**Consultation Response from KC,
Lead Local Flood Authority**

2023/92966 Land to the rear of, 271, Cliffe Lane, Gomersal, Cleckheaton, BD19 4SB

Demolition of existing dwelling and erection of 87 dwellings including formation of a new access from Cliffe Lane, landscaping, public open space and all associated infrastructure and engineering works

**Date Responded: 7th August 2024
Responding Officer: Paul Farndale
Responding Ref:**

Client	QUARTERS DEVELOPMENT		
Project	CLIFFE ROAD GOMERSALL		
Drawing title	PROPOSED LEVELS OPTION 2		
Drawn	MT	Chkd	AD
Date	JAN 23	Scale	1/250
Contract No.	22691-DR-C	Drig No.	0603-1
Revision	P2

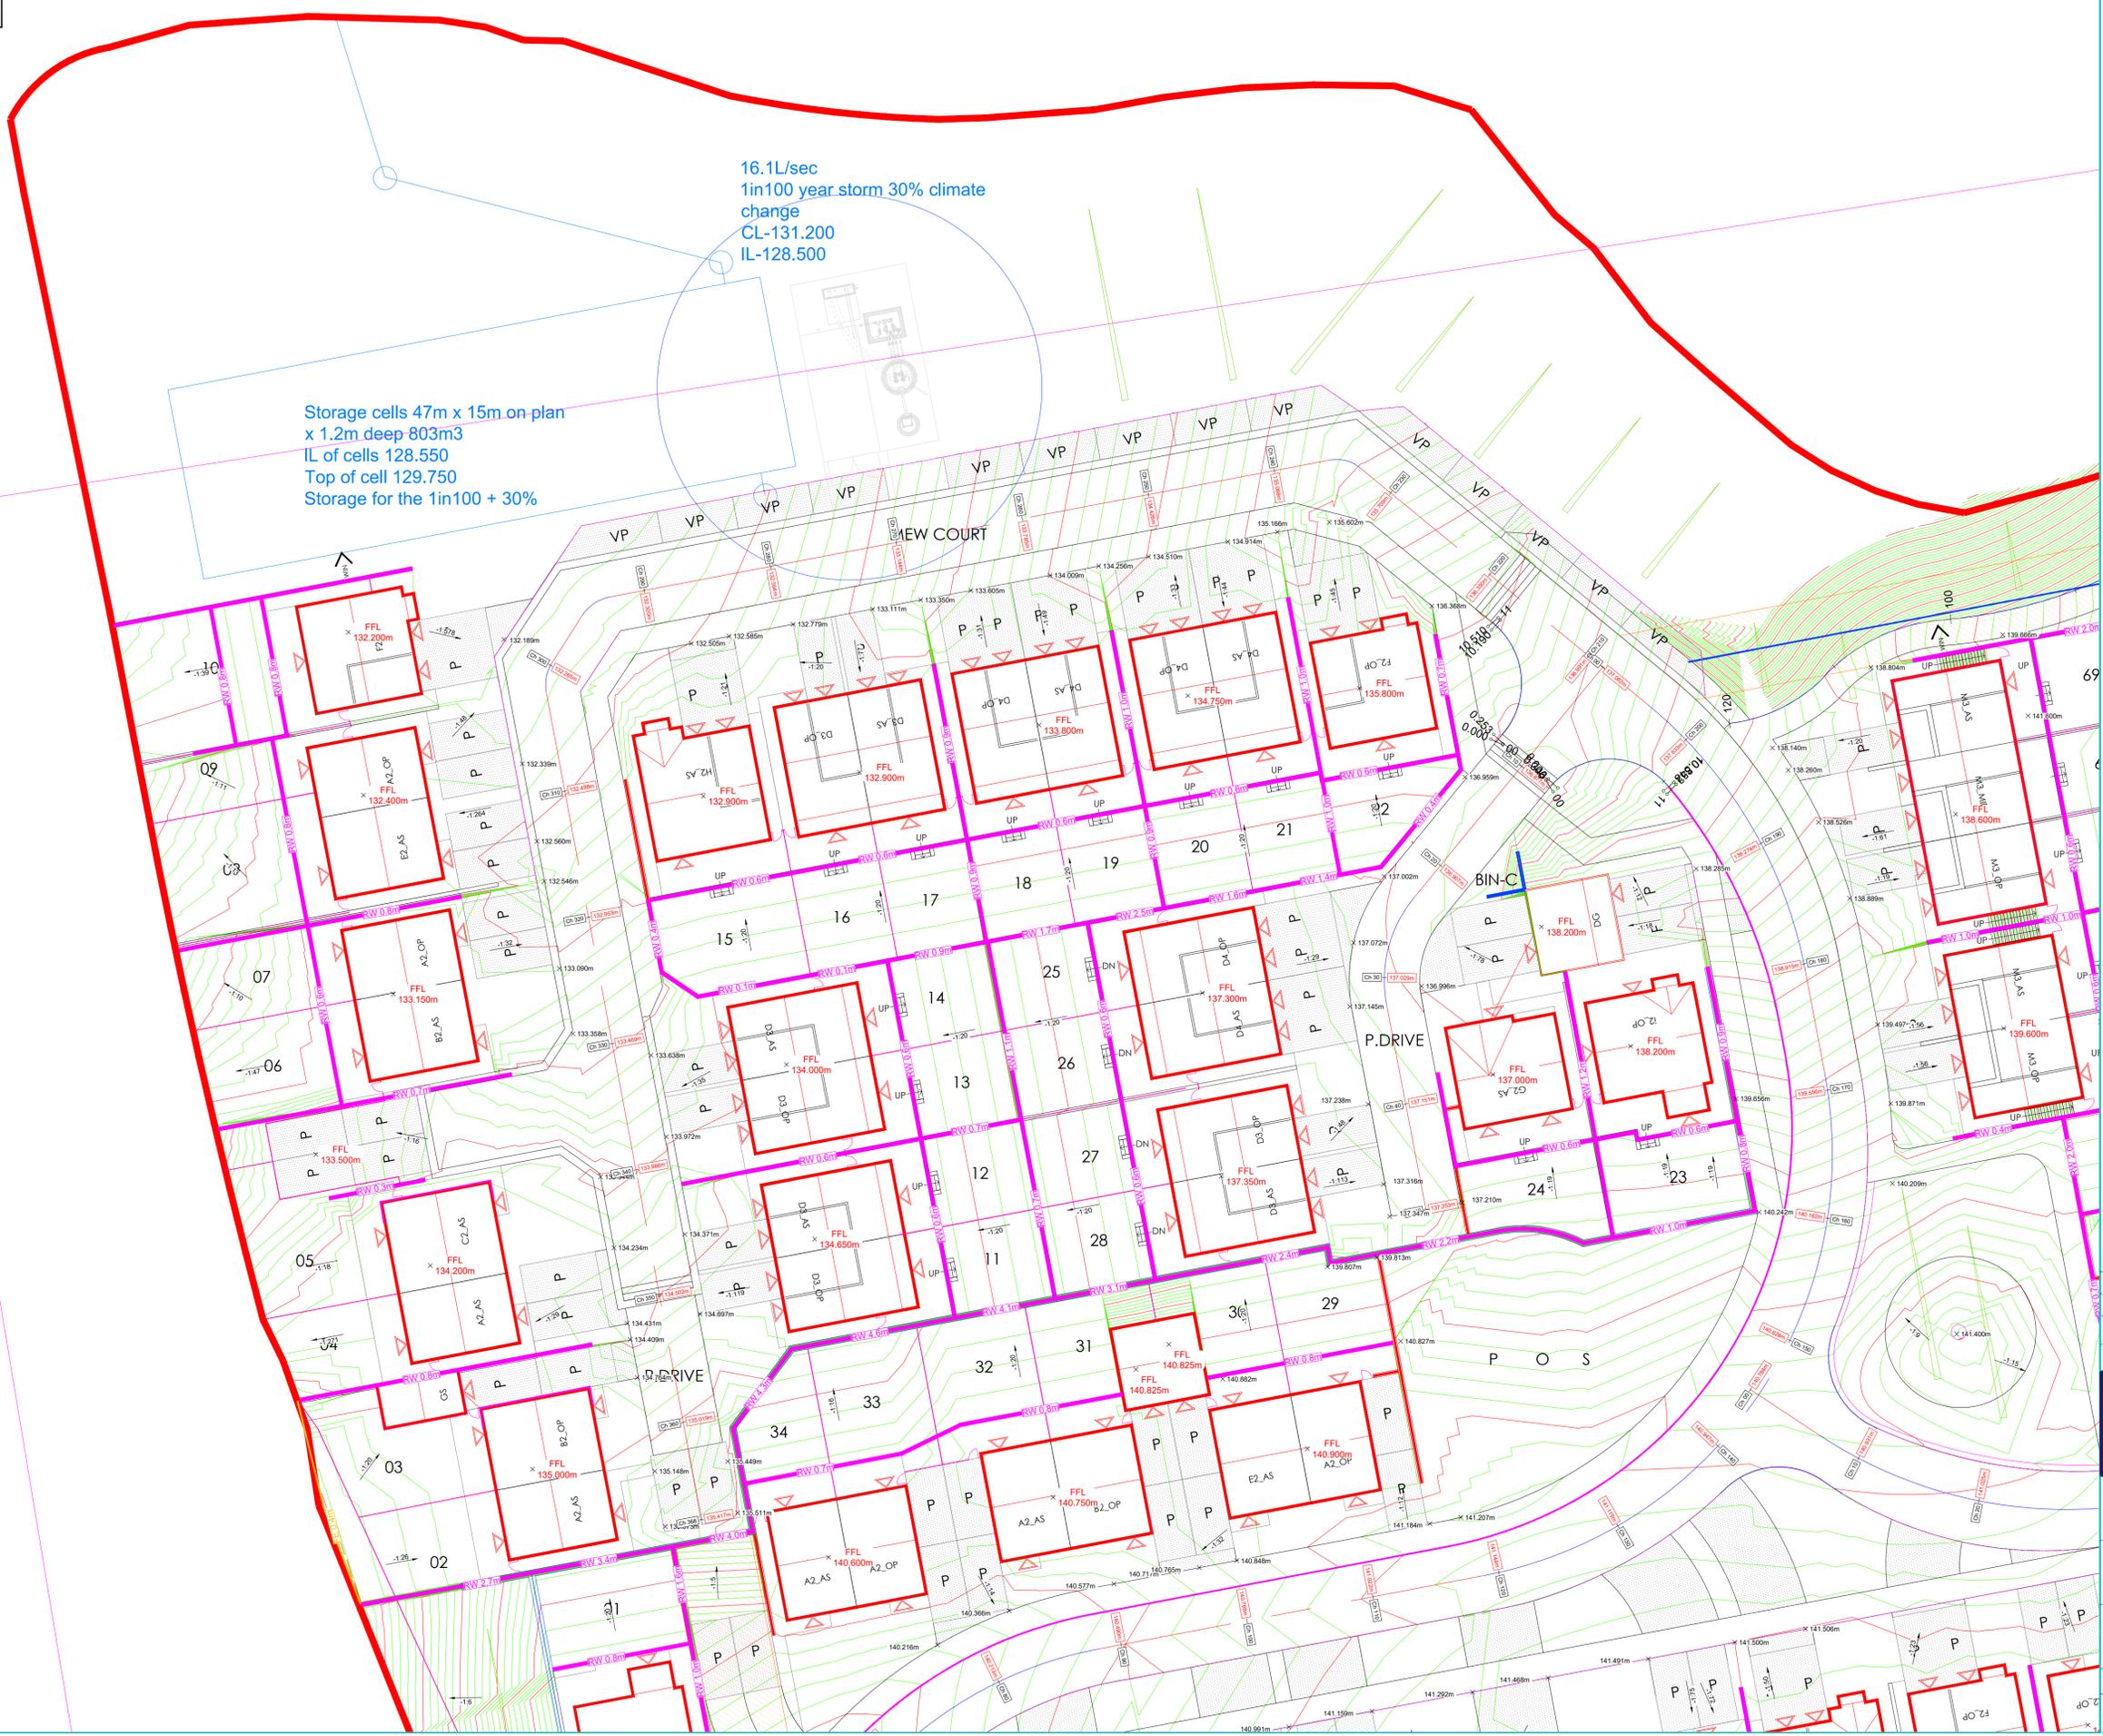
A crate storage system is still show. The LLFA would like to see an indicative tank or a concrete tank in this location. The LPA has an obligation to ensure maintenance and management of SUDS systems for the lifetime of the site. Kirklees will allow crate storage on residential sites only if Yorkshire Water, who assess such matters on a site-by-site basis, produces a technical approval letter for adoption under section 104 of the Water Industry Act 1991.

Supporting hydraulic calculations must show all legs of surface water system and the hardstanding connecting to each. It must show details of the selected attenuation tank so it can be clearly cross referenced with a 'to be agreed' scheme drawing and ultimately plan and cross section of the attenuation tank itself
